From: David Easton
Sent: 20 December 2017 09:19
To: Karen Parsons
Subject: FW: A/155/17/OUT - Avenals Barn, Angmering
Attachments: Proposed dwellings - Plan Elevations.pdf; Proposed dwellings - Site plans.pdf

Subject: A/155/17/OUT - Avenais Barn, Angmering

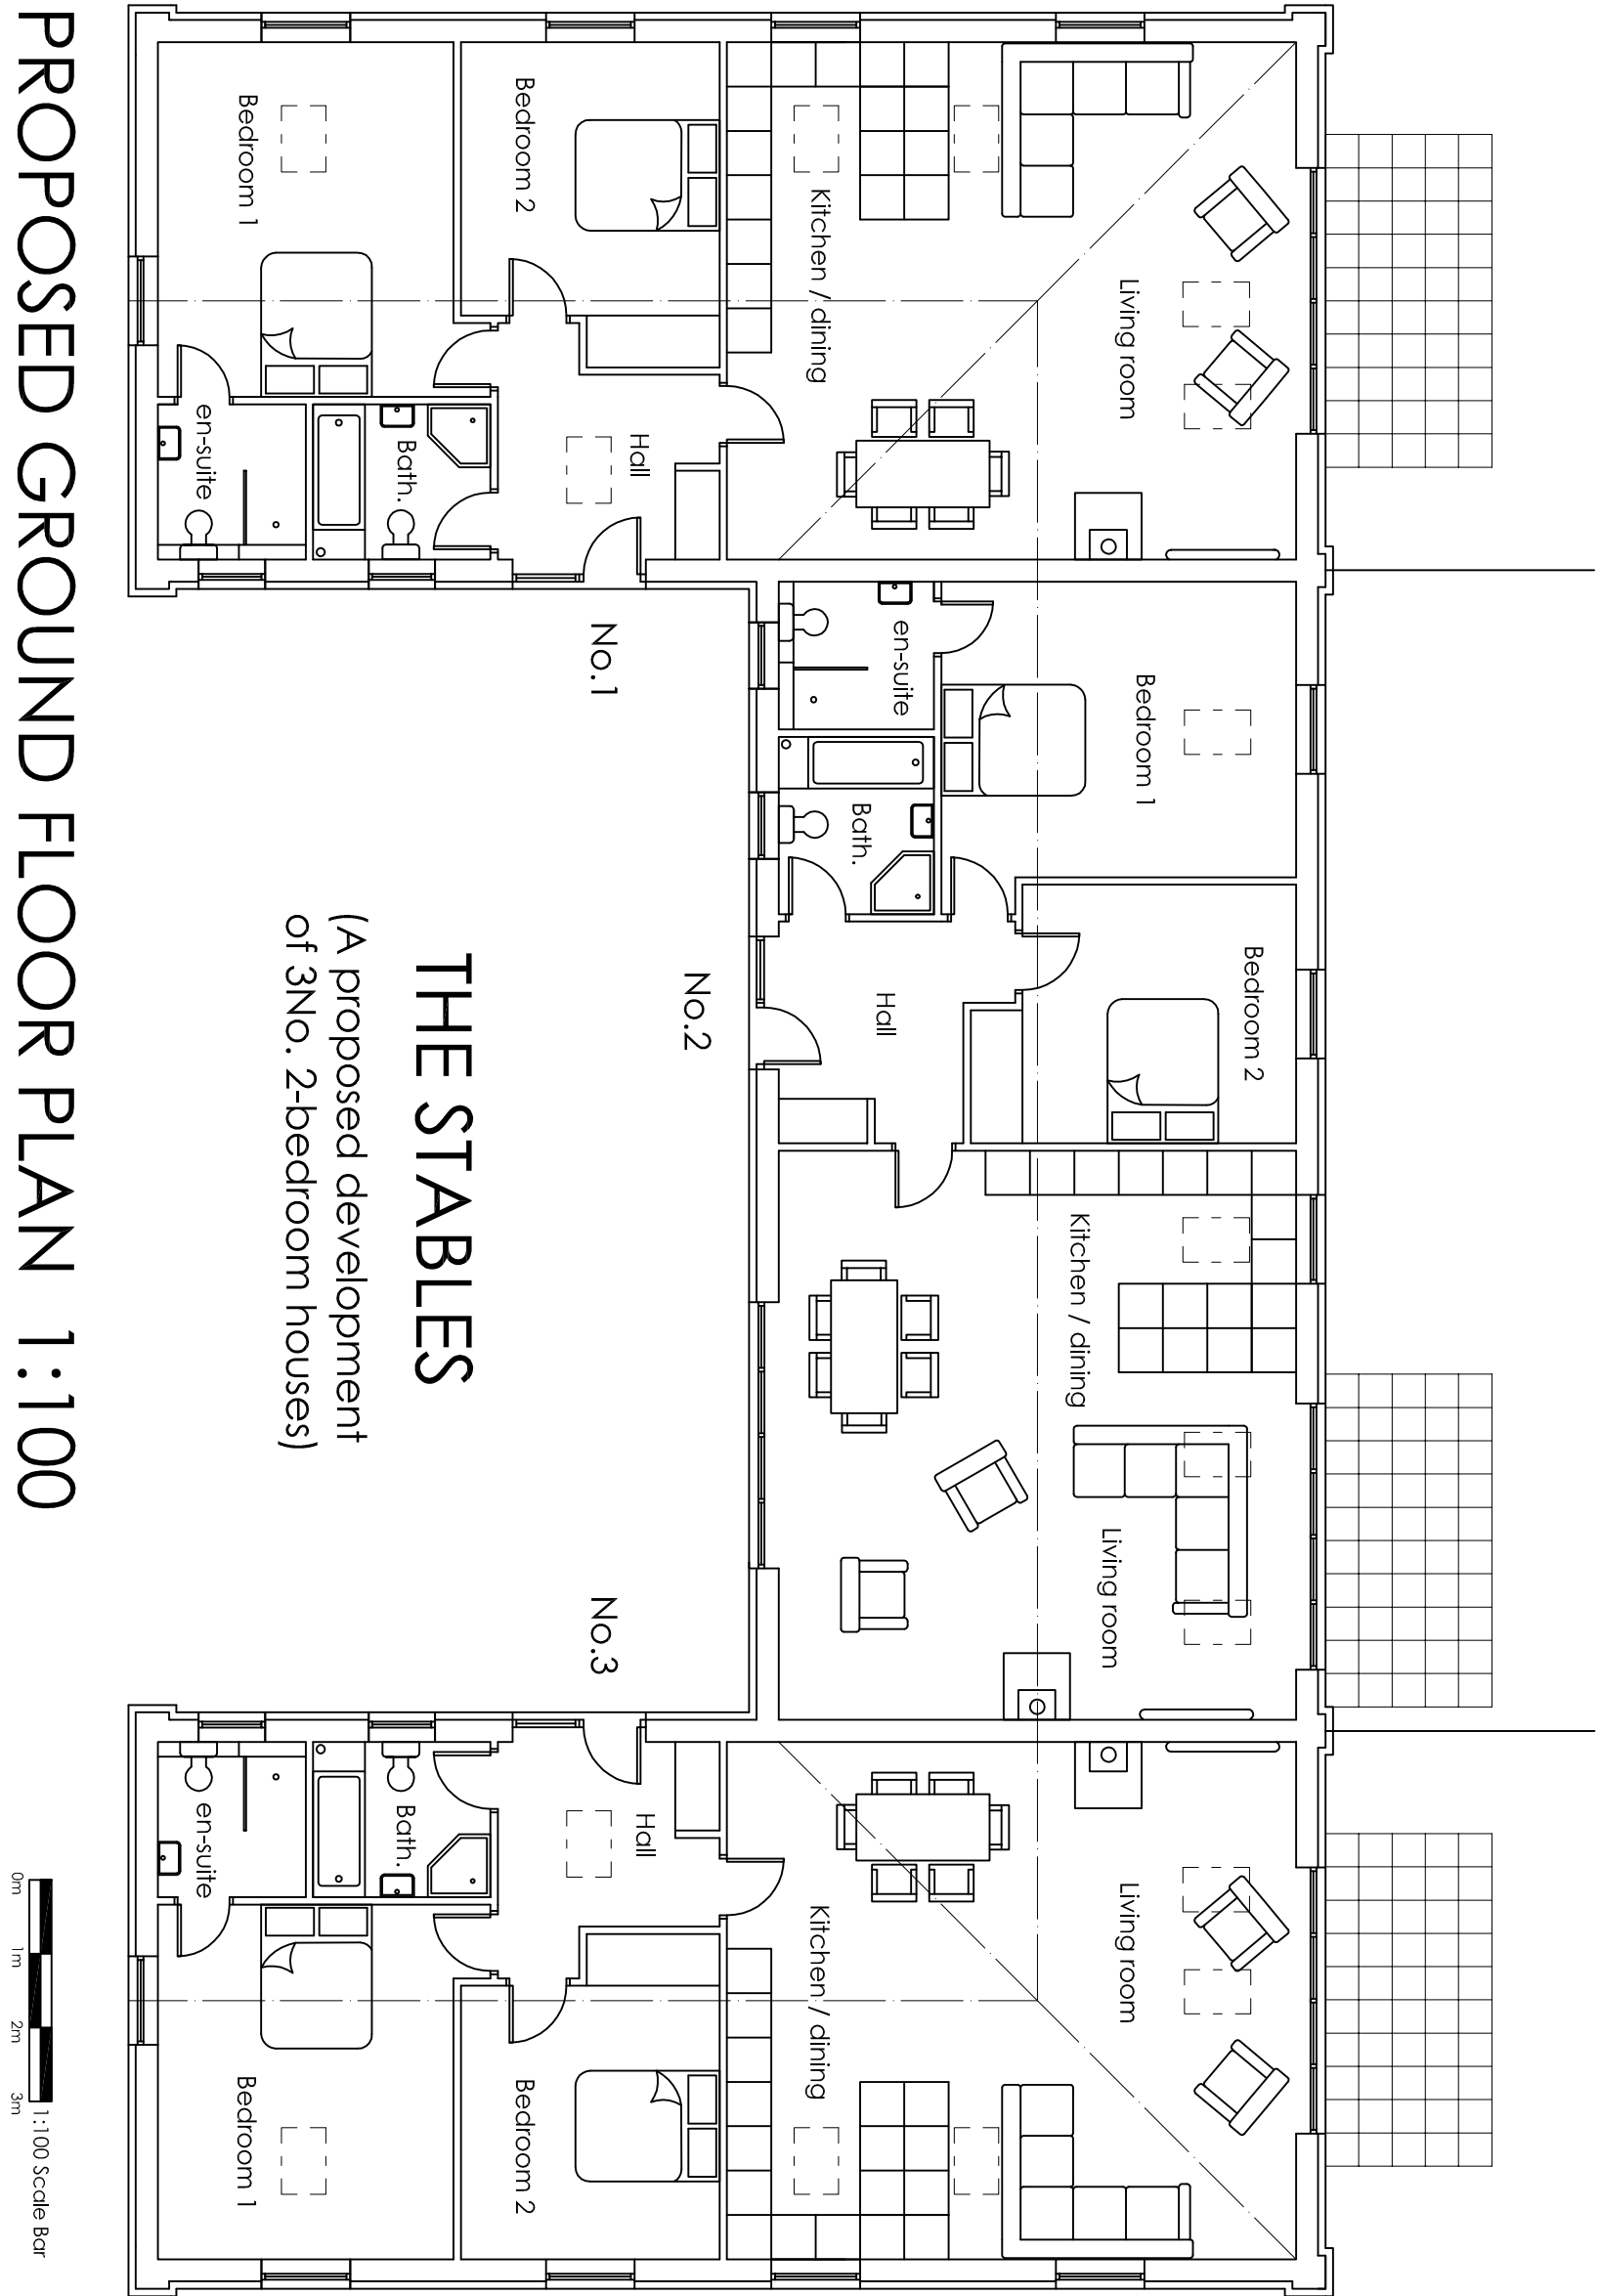
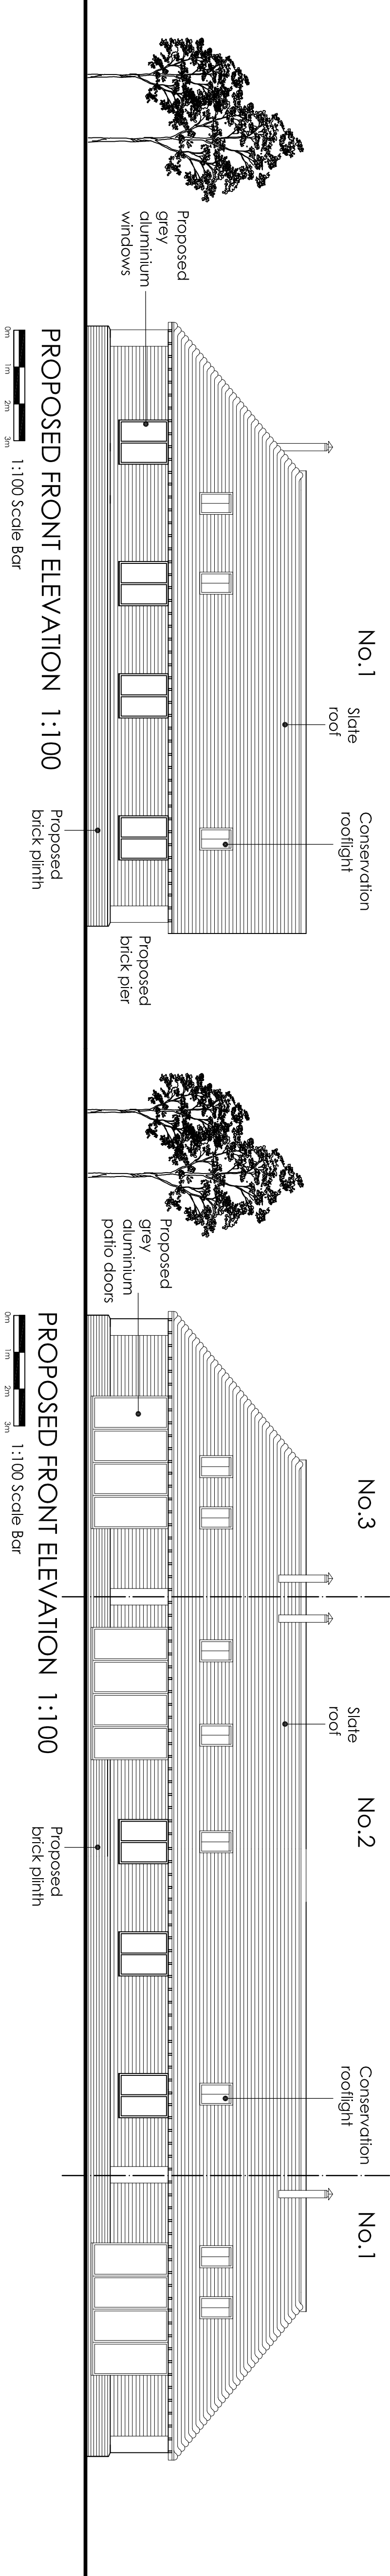
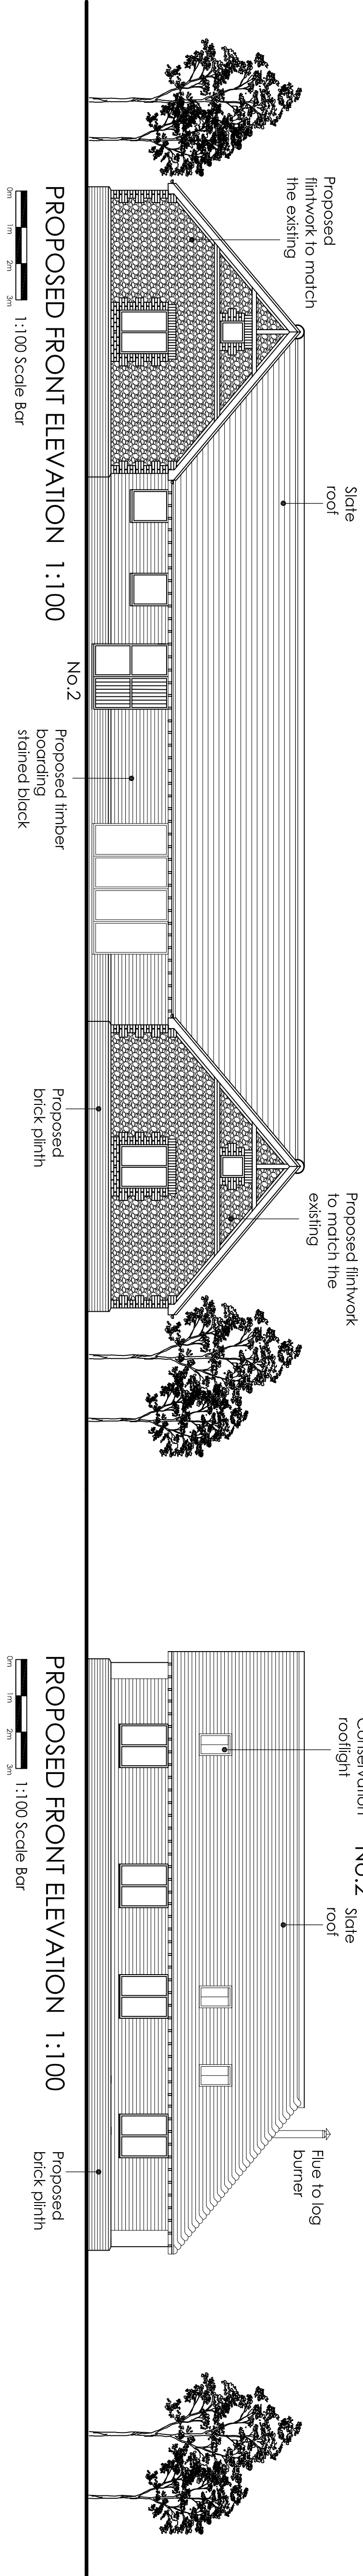
I am also aware of your concerns regarding the comments of the Council's Conservation Officer and I will try to discuss this with her when she is next in the office.

1. The depth of the rear gardens have been increased to 10m
2. In order to provide sustainability, a footpath / cycle link has been included to Weavers Hill. Please note that the client owns this plot of land and therefore the blue line has been extended around the field.
3. The patio door to the front elevation has been removed and replaced with 2 windows. The patio doors will only be seen from the rear of the property.

With regard to No.3 above we appreciate the comments made by the Conservation Officer and will consider the advice at Full Planning stage, if the outline planning application is approved. I have attached a couple of photos below to show the type of glazing we would like to propose which we believe would not have a detrimental impact to the existing buildings. Our proposal would like to replicate certain elements of the existing details from Avenals Barn but we would also propose some modern parts to differentiate between the new buildings and the older parts of the property. The photo below also shows the type of conservation roof lights that would be used on this development.
